Project# 1010407 - 15DRB-70146 MINOR - PRELIMINARY/ FINAL PLAT APPROVAL

PROJECT NAME: CASAS ESCONDIOAS

**April 15, 2015
DRB Comments**

RE: Lot 2, Casas Escondidas

PLAT OF  
**LOTS 2A & 2B**  
**CASAS ESCONDIDAS**

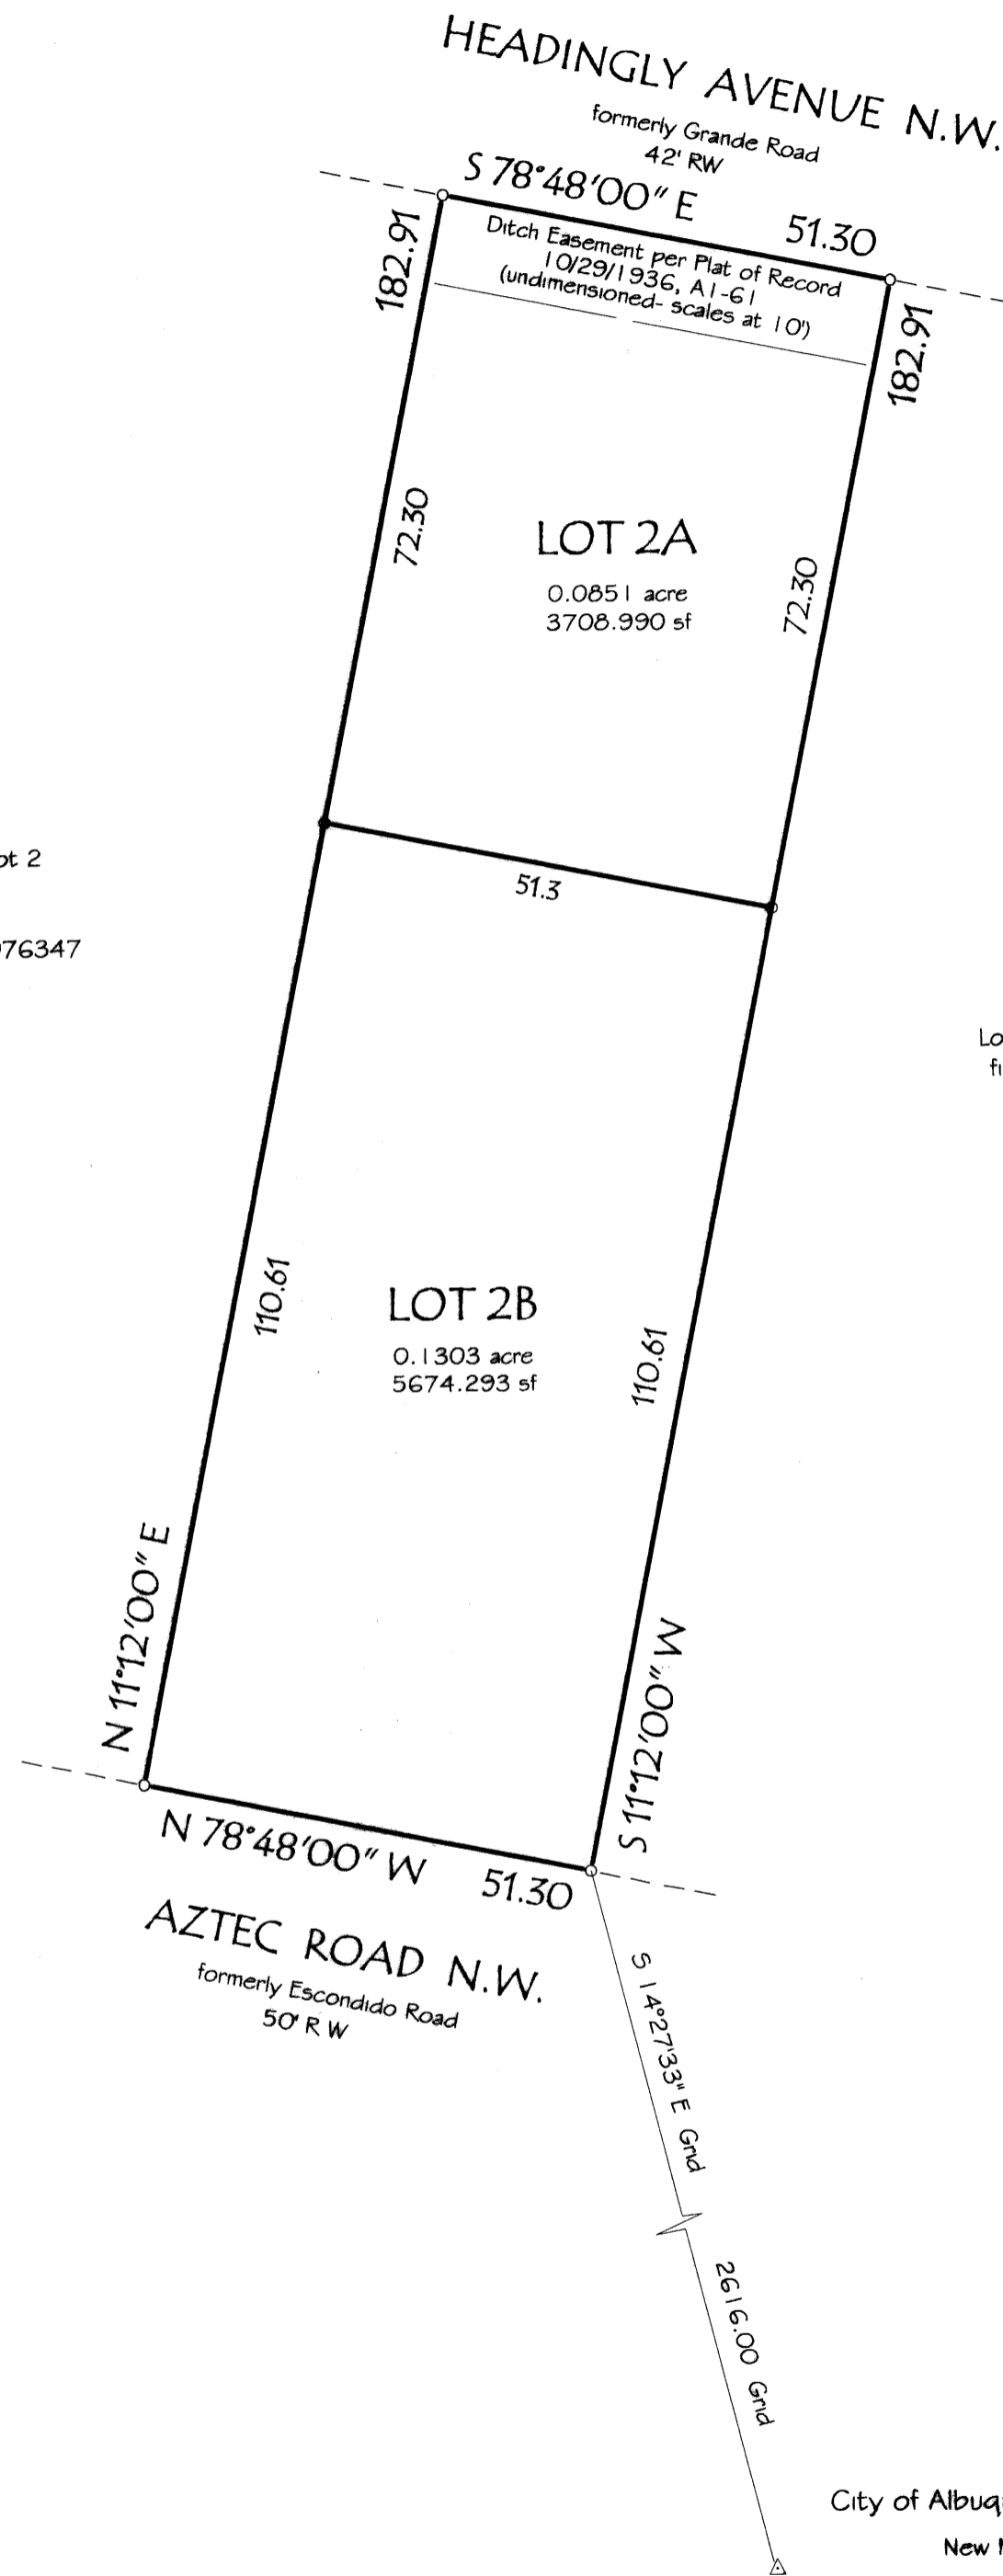
Please provide a reference on the plat to the 1952 Deed that documents the creation of "Portions of" Lot 2 prior to the 1973 Subdivision Ordinance; please delete reference to 2011 Quit Claim Deed.

There appears to be a shed located on the proposed lot line – please verify location consistent with the Zoning Code.
